CITY OF PORTLAND, MAINE
DEVELOPMENT REVIEW APPLICATION
PLANNING DEPARTMENT PROCESSING FORM
DRC Copy

20-34 Fuller St., Hale & Bartlett

Approval Conditions of DRC

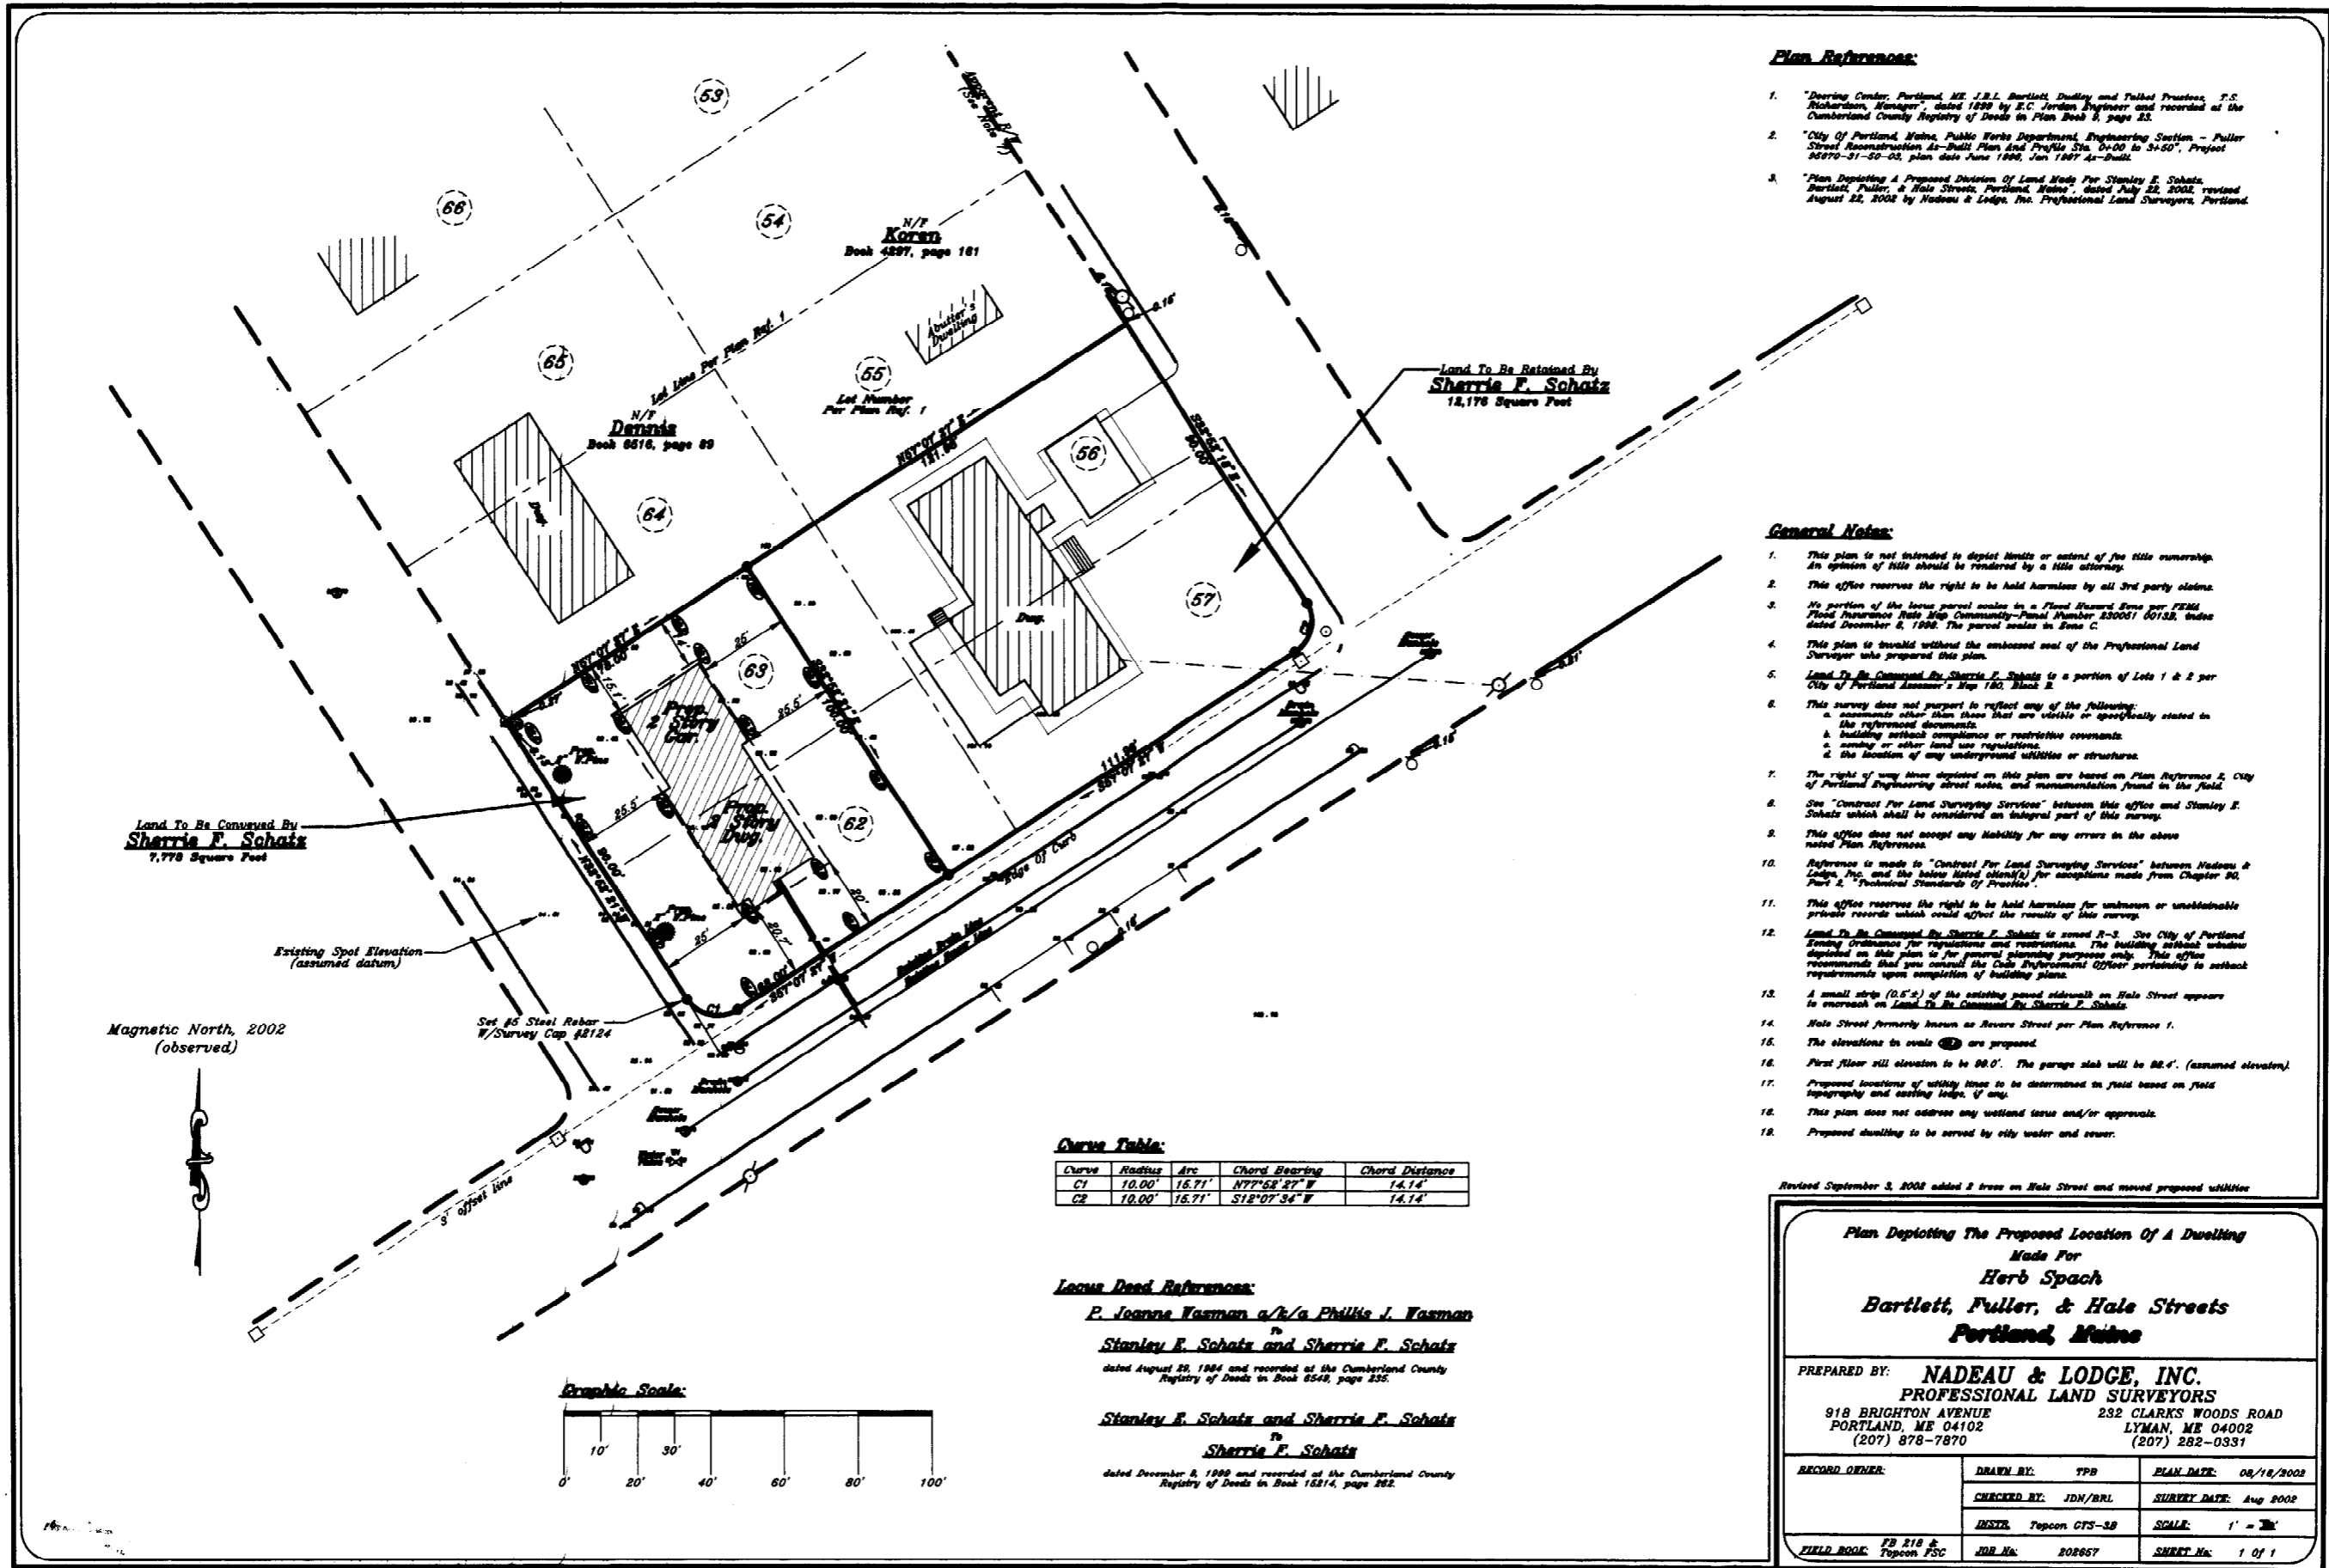
- 1 APPLICANT SHOULD BE AWARE THAT FULLER STREET HAS BEEN RECENTLY RESURFACED, AND THAT SIGNIFICANT FEES AND RESTORATION PRACTICES ARE REQUIRED AS A RESULT OF THE ROAD OPENINGS FOR UTILITIES.

- 9 The site contractor shall establish finish grades at the foundation, bulkhead and basement windows to be in conformance with the first floor elevation (FFE) and sill elevation (SE) set by the building contractor to provide for positive drainage away from entire footprint of building.
